MORGAN AND MORECAMBE OFFSHORE WIND FARMS: TRANSMISSION ASSETS

Annex 3.2.3 to Response to RR - Environment Agency (RR-677)

Document Reference: S_PD_3.2.3

11 April 2025
F01

Figure 1.4: Watercourse and waterbodies scoped in and survey numbers – Section 3

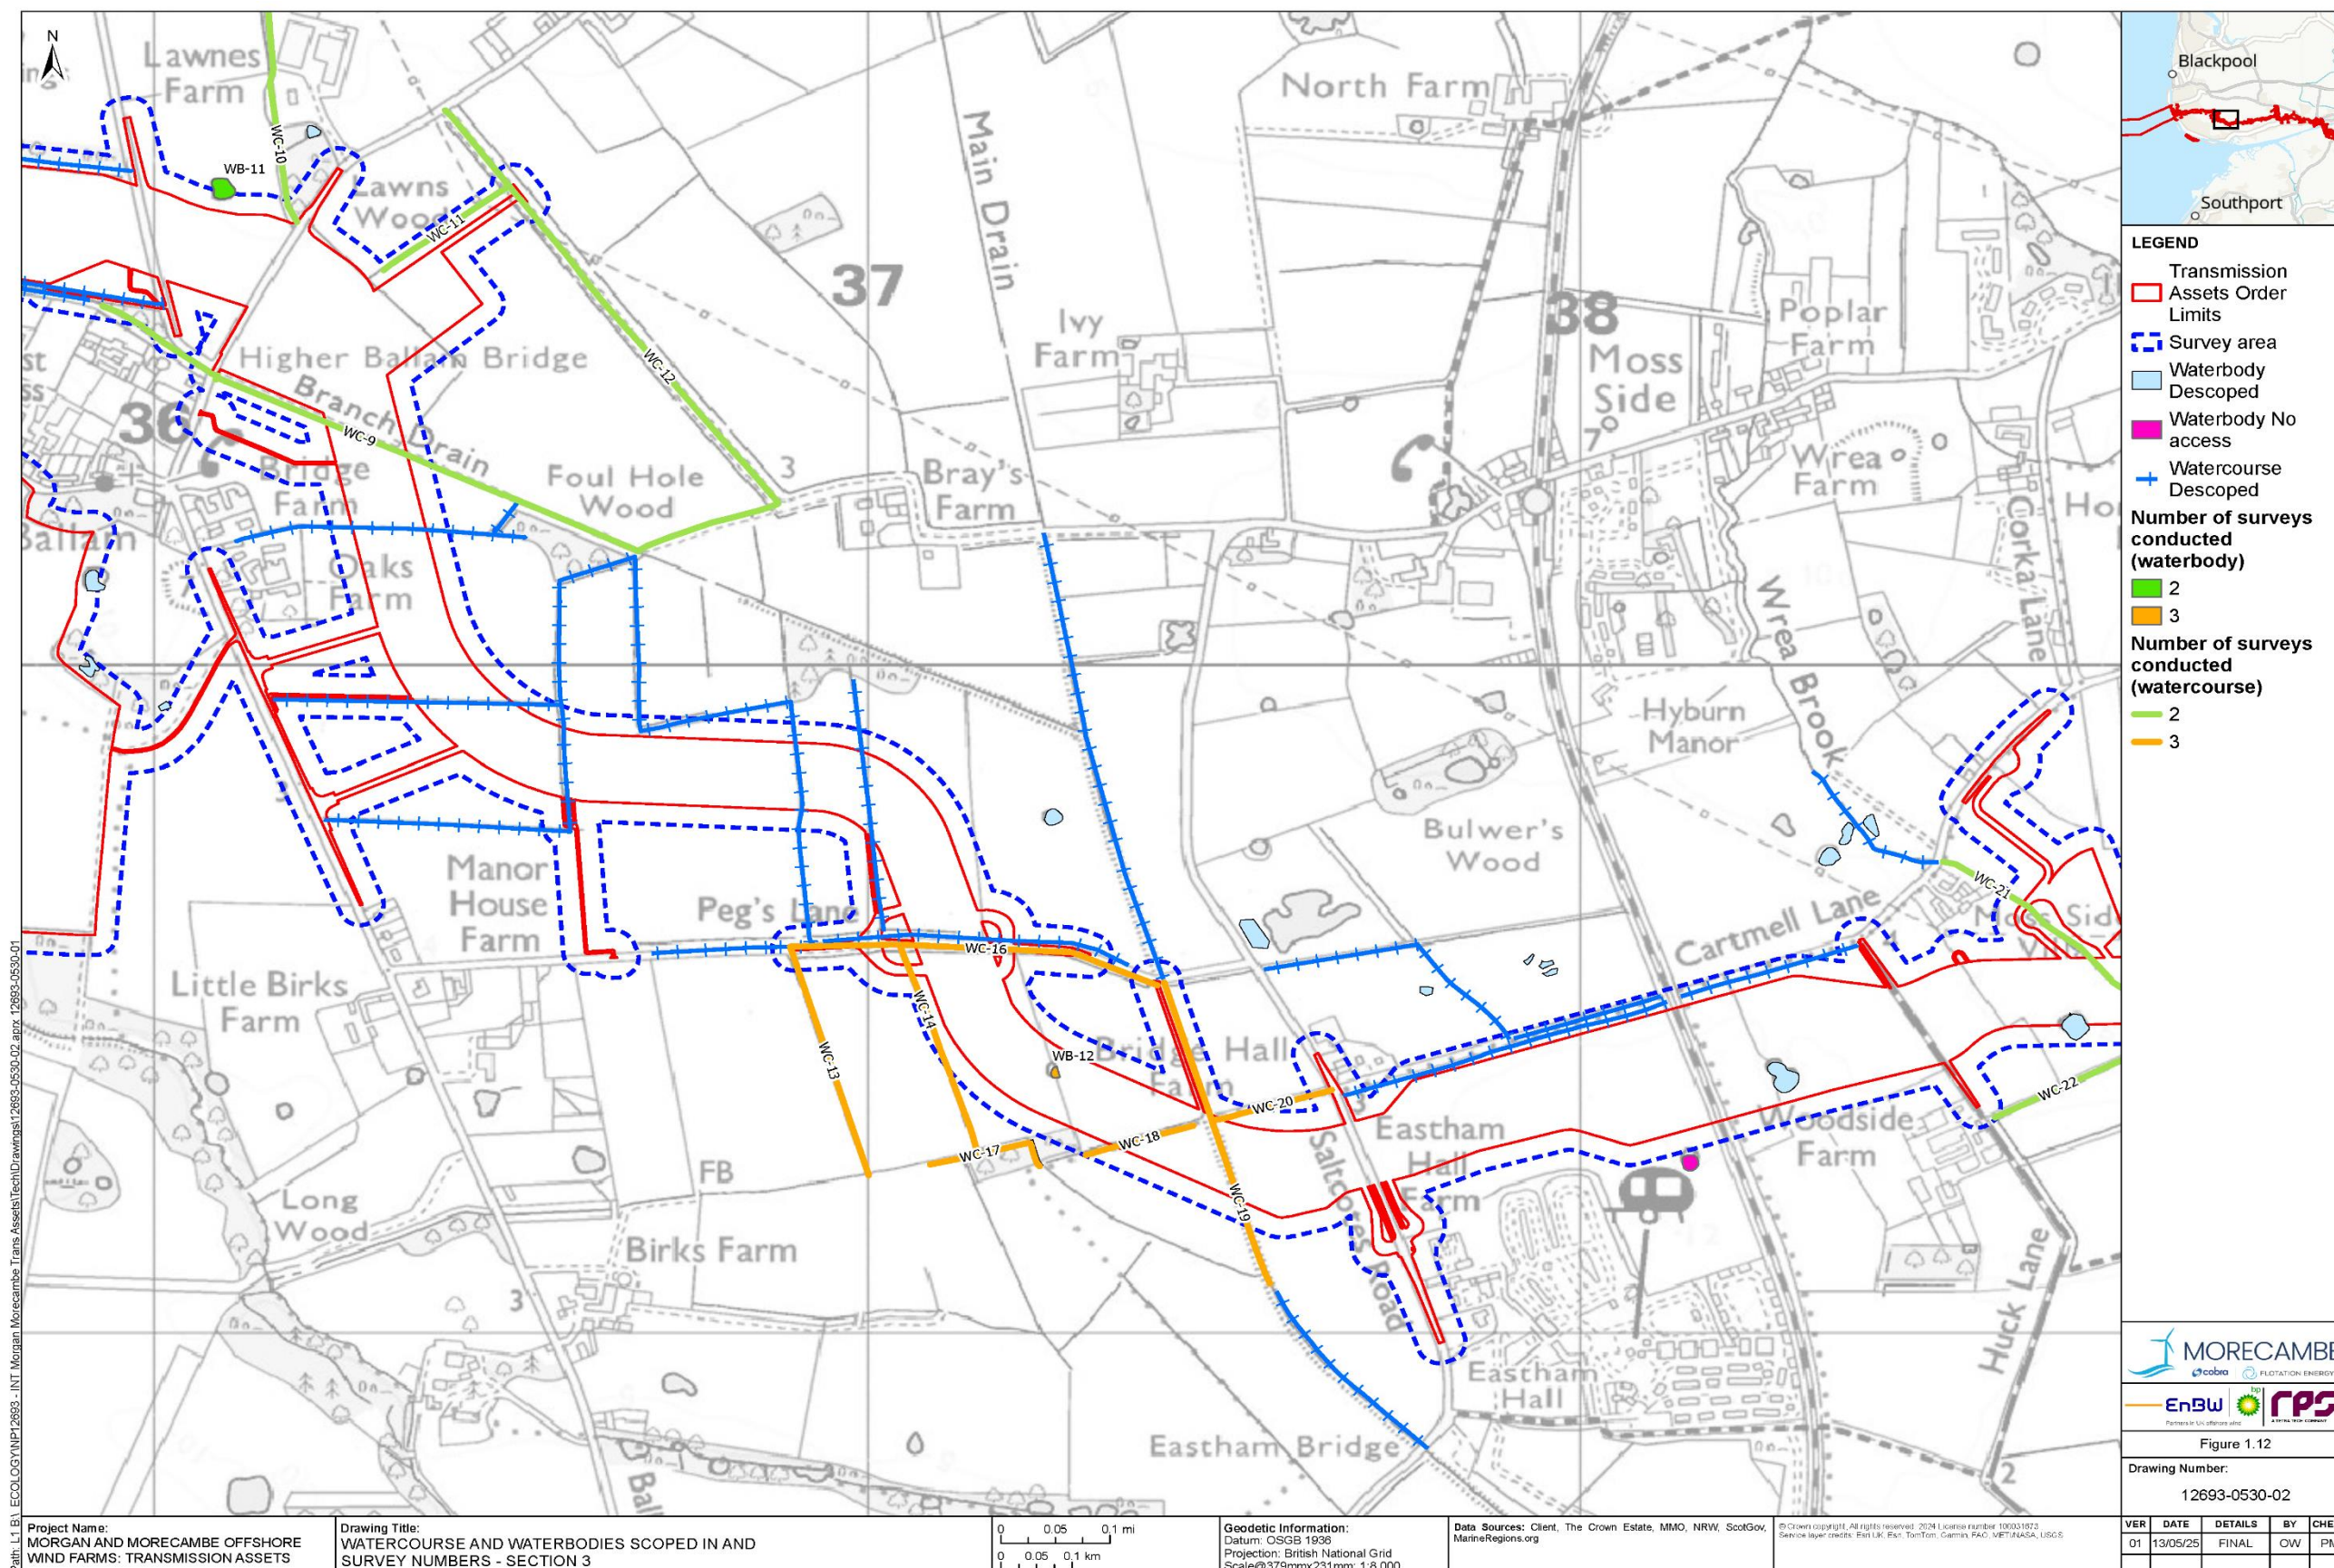
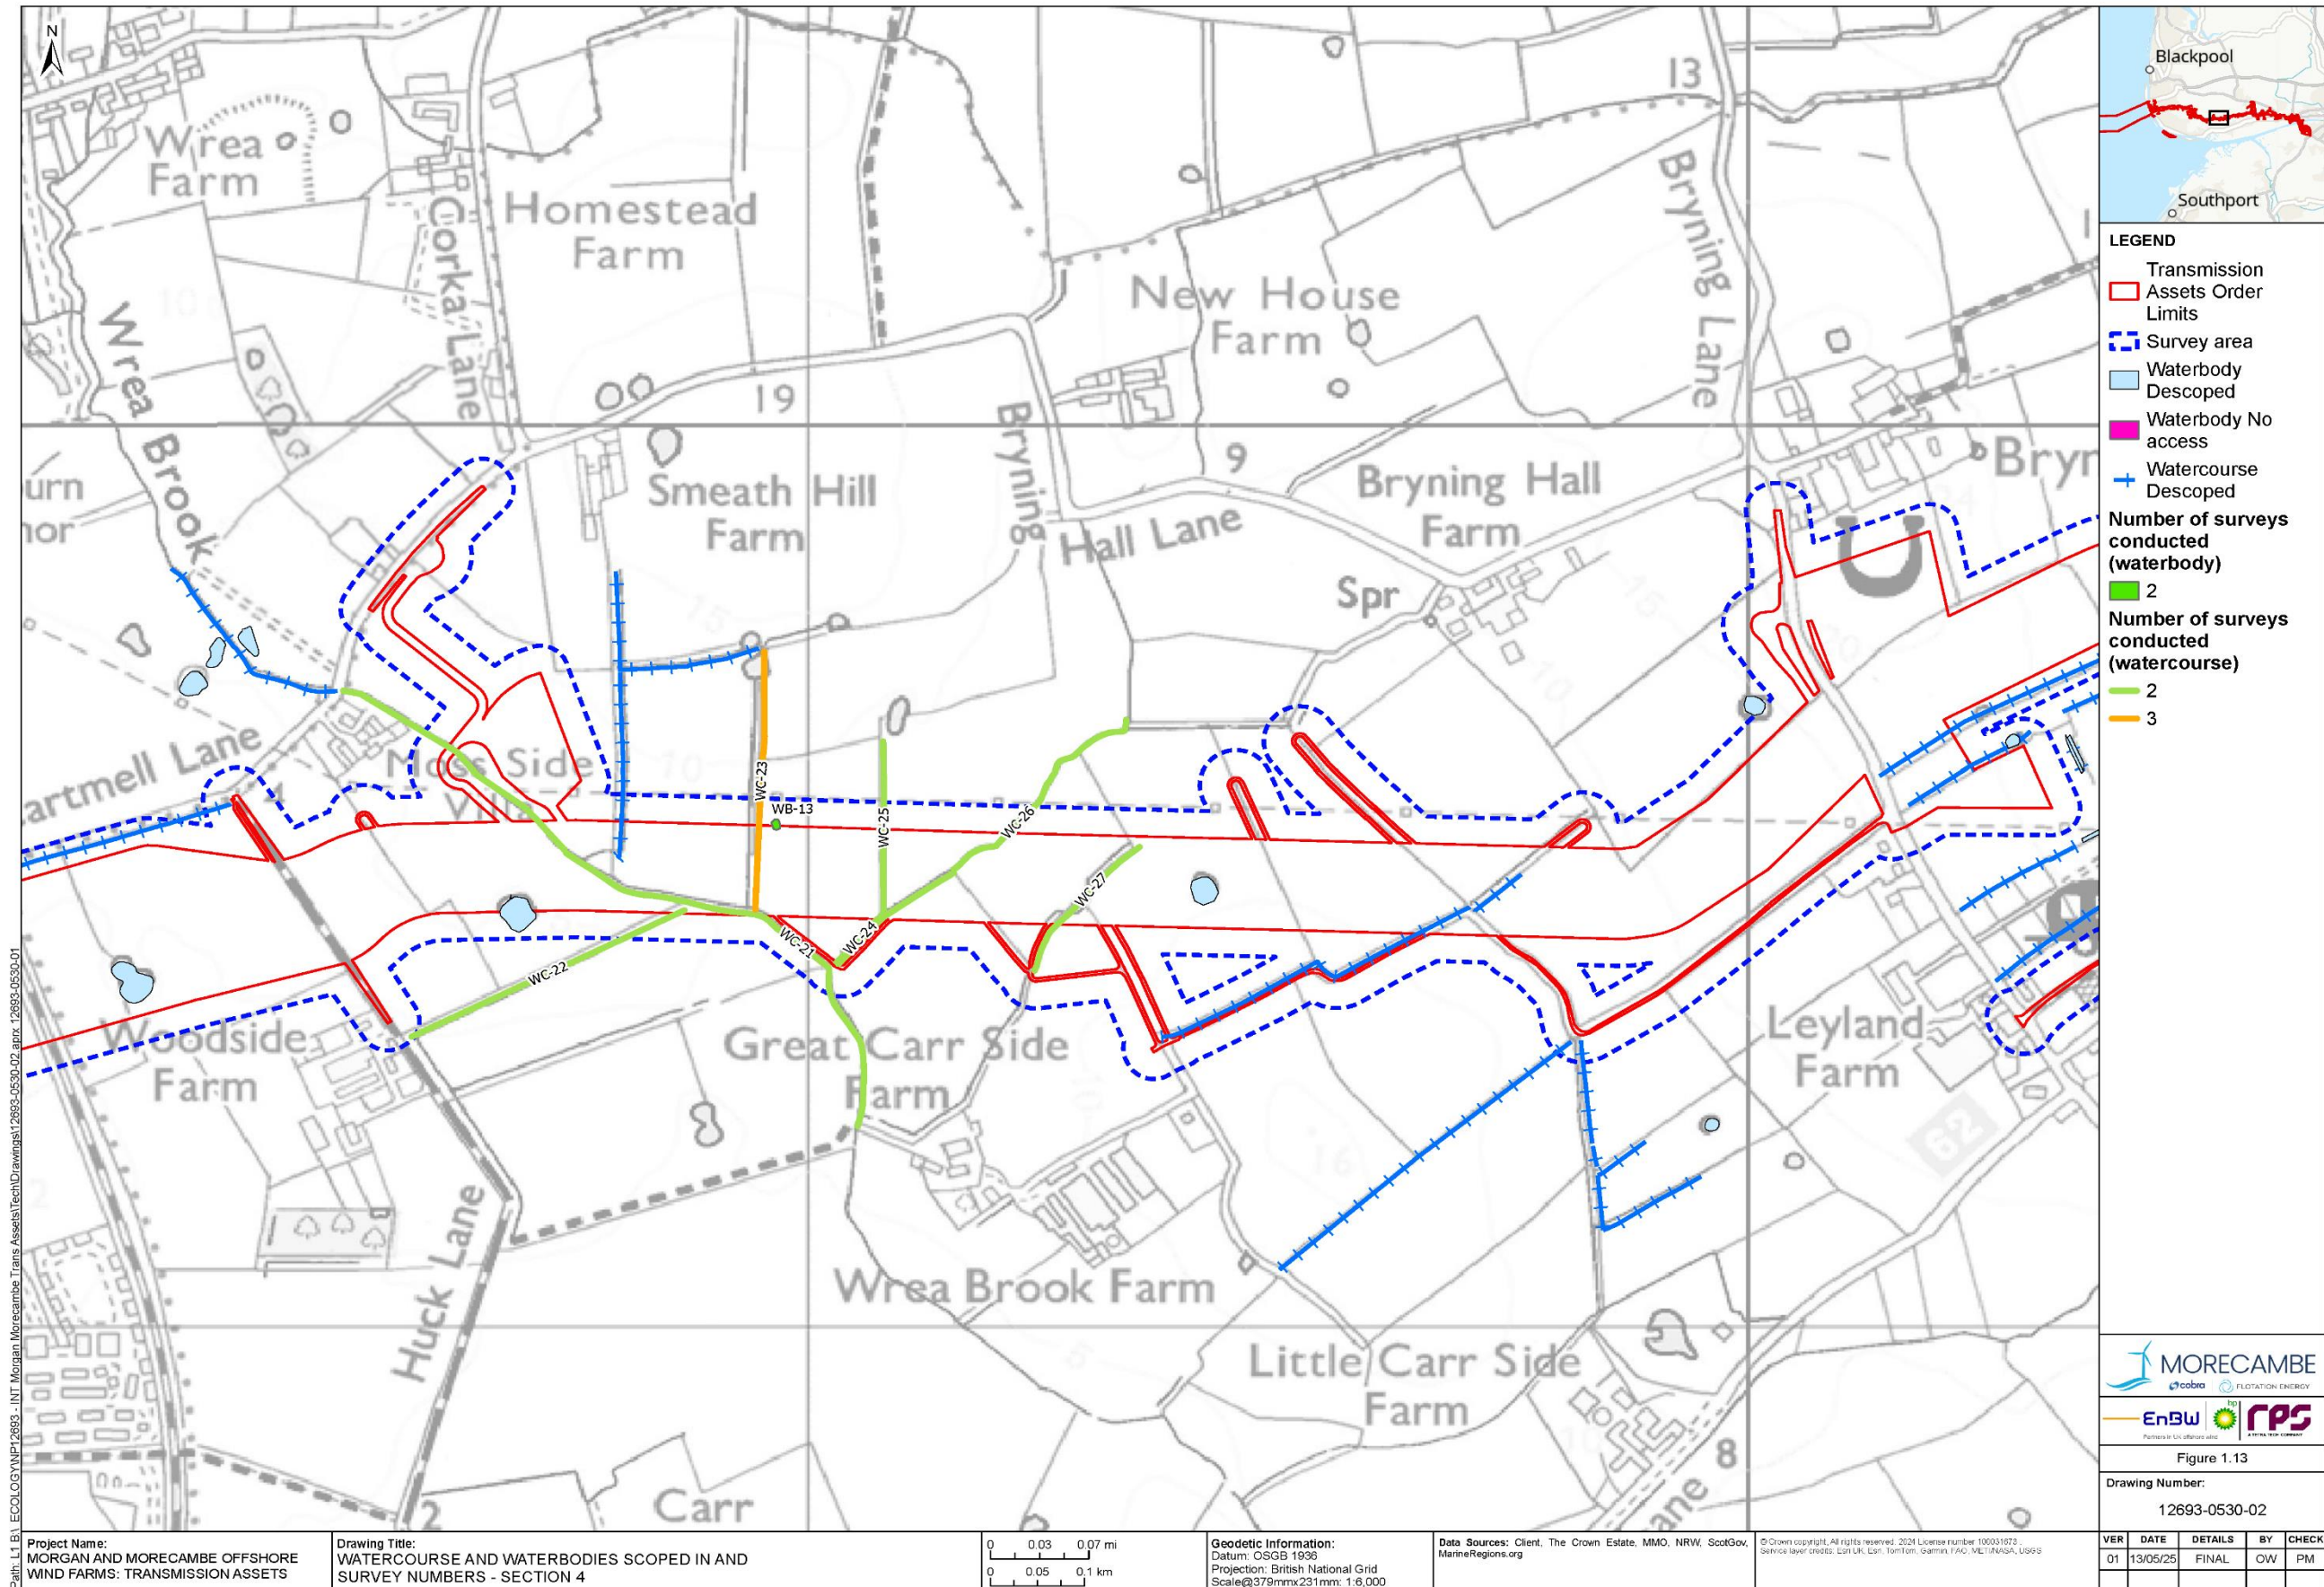
RR-0677 0677.12 (Appen. 1 APP-083)	<p>Water vole survey technical report</p> <p>Section 1.2.4.16 and 1.2.4.17: Water vole surveys have been undertaken following periods of weather extremes. The surveys in June 2023 were undertaken following an extended period of hot dry weather. The survey in April 2024 was undertaken following a period of heavy rainfall.</p> <p>Possible under-recording. Evidence of water vole are less likely to be recorded following dry weather, and evidence may be washed away during heavy rainfall.</p> <p>The report confirms that 'late season' water vole surveys were ongoing at the time of DCO submission. Once complete this report should be updated to reflect the results and submitted for review.</p>	<p>A campaign of water vole surveys was undertaken between April 2023 and July 2024 on land parcels with habitat that could potentially support water vole and where access was agreed. The surveys were undertaken in accordance with the methodology agreed with the Environment Agency (as part of the EWG) and the results were reported in Volume 3, Annex 3.9: Water Vole Survey Technical Report (APP-083). The water vole survey methodology requires two visits within the breeding season (i.e. early season (between mid-April to June) and late season (between July and September)).</p> <p>The Applicants responded to comments regarding the weather conditions during the June 2023 water vole surveys in Table 3.5 of Volume 3, Chapter 3: Onshore Ecology (APP-075) and subsequent surveys were undertaken in 2024 where access was permitted. A summary of the surveys (as set in Table 3.15 of APP-075) found there was little confirmed evidence of water vole and (together with the infrequent but widespread evidence of mink) considered water vole to be of local importance within the survey area. However, a precautionary approach was adopted for the assessment which assumed that water voles to be present where potentially suitable habitat had been recorded.</p> <p>The Applicants confirm that water vole surveys were undertaken in late August, September 2024 and the first week of October 2024 (as weather conditions allowed the</p>

Reference	Relevant Representation Comment	Applicants' response
		<p>surveys to be recorded as a 'late season' survey). These surveys formed part of the late season surveys that were being completed in accordance with the seasonal survey restrictions and the methodology of the previous water vole surveys. Given the timing of the surveys, the results were not included in the DCO application.</p> <p>The Applicants confirm that Volume 3, Annex 3.9: Water Vole Survey Technical Report (APP-083) will be updated to show the location of these surveys and will be submitted at Deadline 1 of the DCO Examination. The Applicants confirm that no new evidence of water voles was recorded during the late August to early October surveys and therefore, the characterisation of the baseline and the conclusion of the assessment as reported in Volume 3, Chapter 3: Onshore Ecology (APP-075) remain unchanged.</p> <p>Preconstruction surveys for European Protected Species (including water vole) will be undertaken (as secured in Requirement 13 of Schedules 2A & 2B the draft DCO (AS-004)). As set out in the Outline Ecological Management Plan (OEMP) (APP-212) the water vole surveys will be undertaken along all ditches of potential value to water voles that would be affected during construction.</p>
